Re: Wal-Mart at 301 San Mateo Blvd SE, Transportation Comments

Please find responses below in bold addressing the Transportation Development Comments received February 18, 2021.

SECP-2B

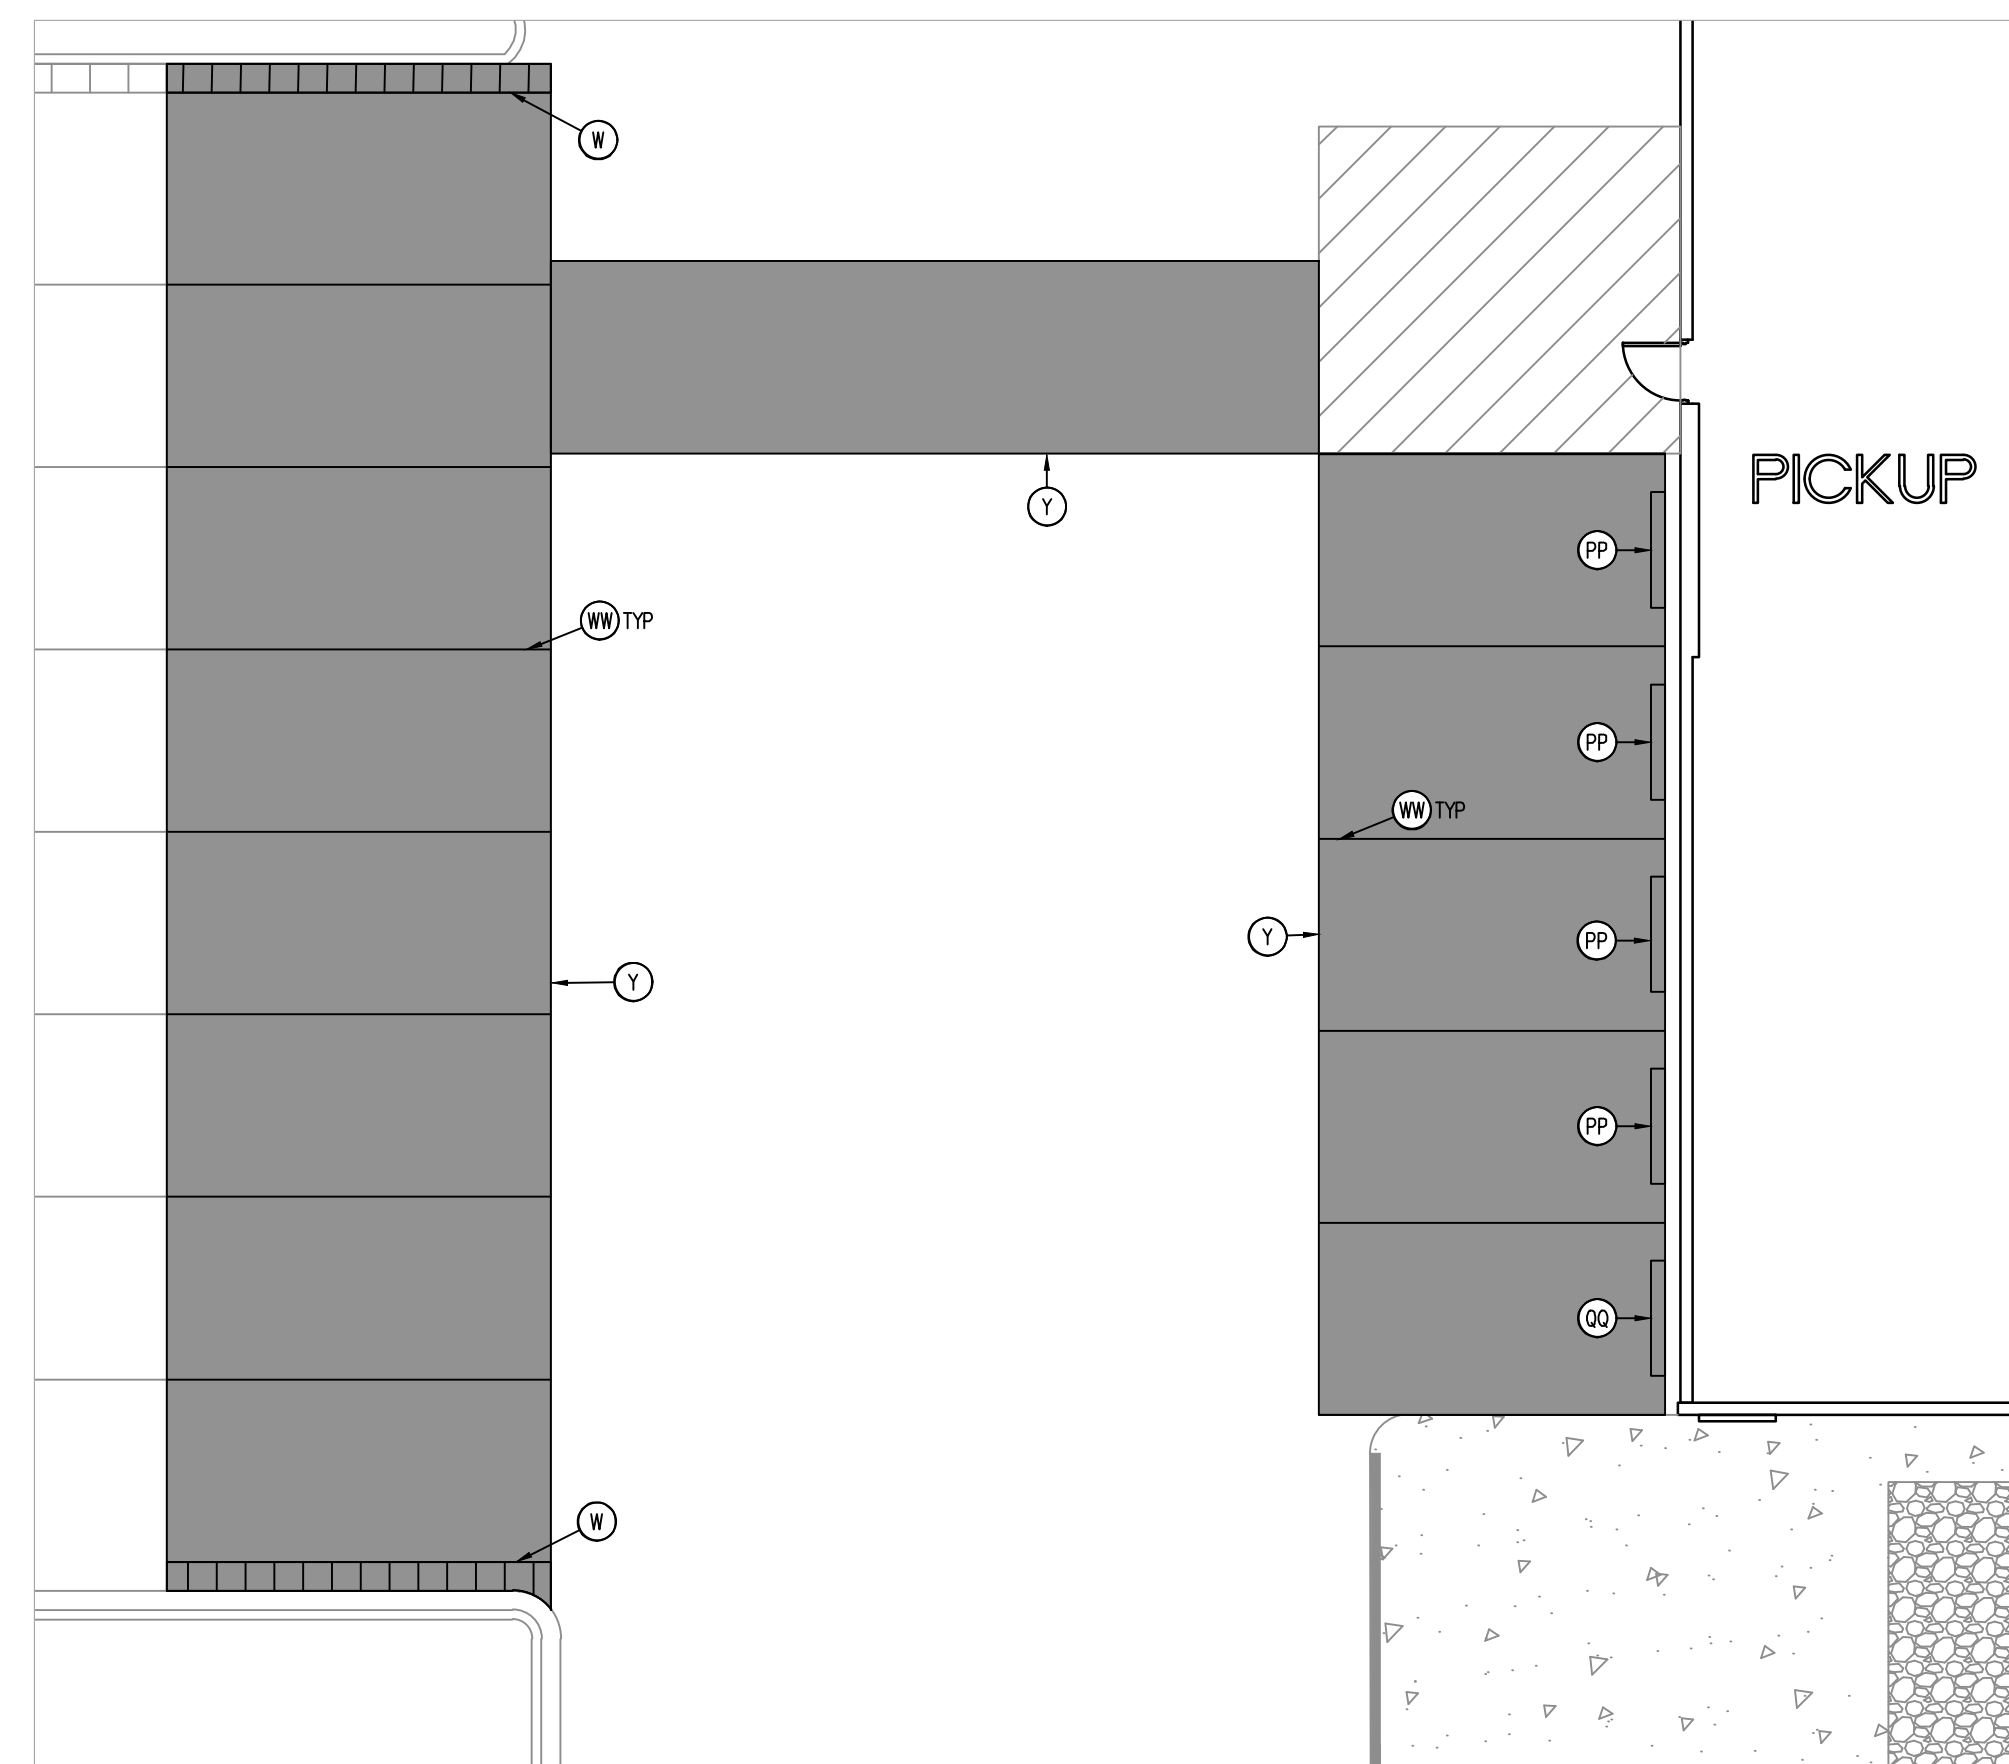
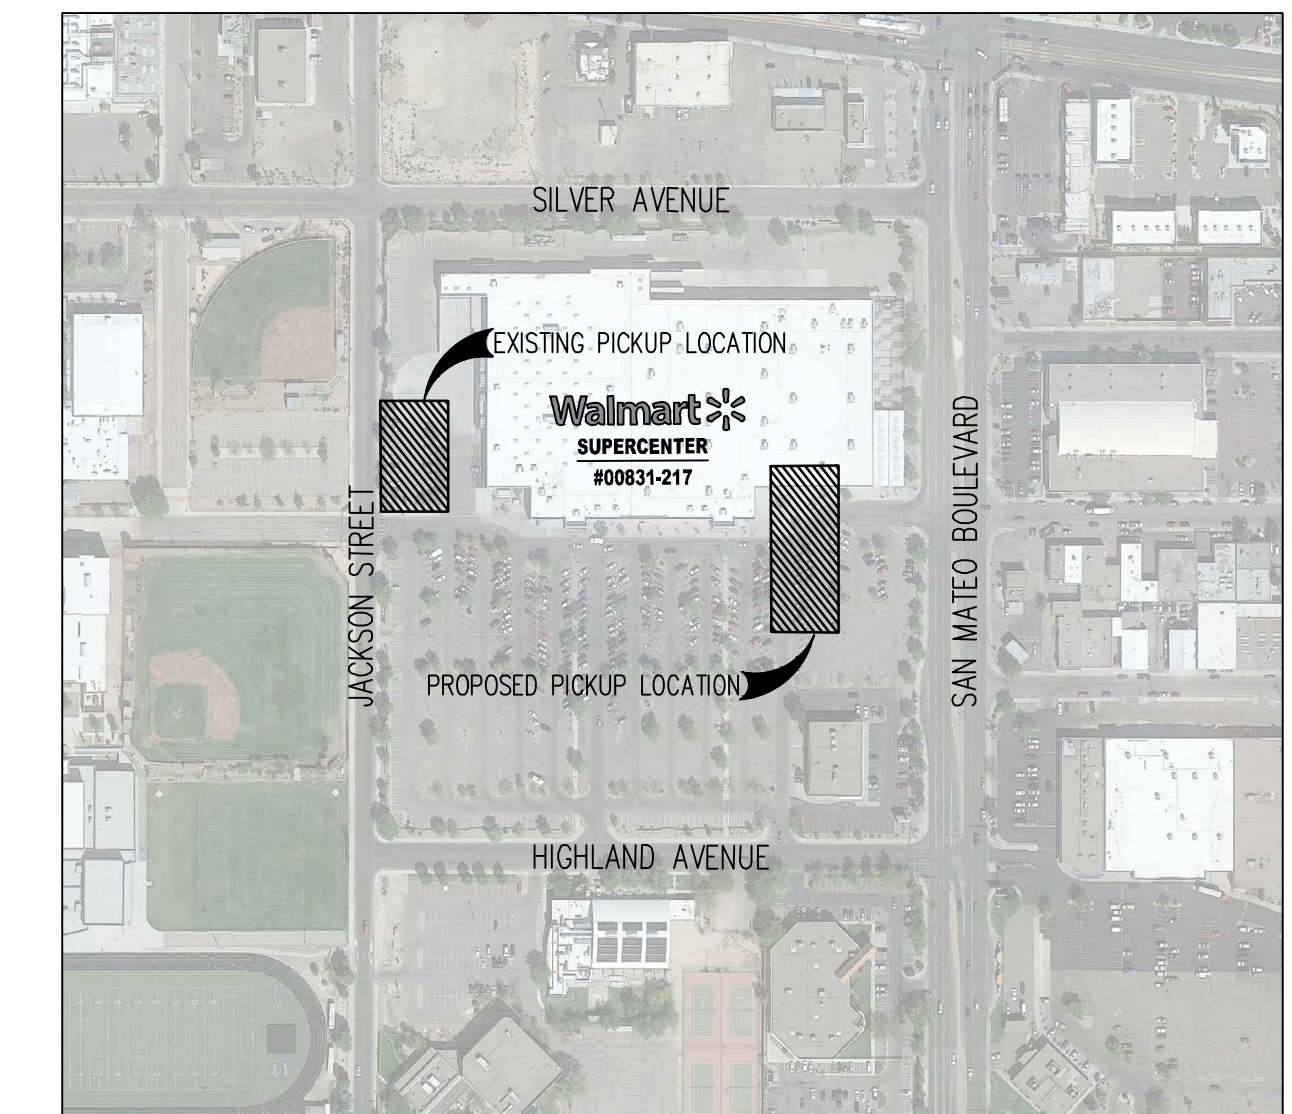
2. With the new pick-up area, was it intentional to leave the parking lot spaces the same width, or widen them? If making any changes, label widths as needed and indicate any parking space reductions while making sure minimum space requirements are met.

3. On the new pick-up layout plan, you had the keyed note "V" marked at the back of the parking space where it seems to be in error.

4. The stop bar at the new pick-up space should be moved further northeast to not conflict with the parking space.

5. For new bollard placements, indicate distance to driving aisle.

Response: It was intentional to leave the stall striping in the same condition as the striping is today, same widths and single stall striping.

Response: This was in error and has been revised.

Response: This has been shifted

Response: Dimension have been added to both sides of the Pickup stalls from the signage to the edge of drive lane on sheet SECP-2B. The signage will be on temporary bases and not bollards as locations are temporary condition.
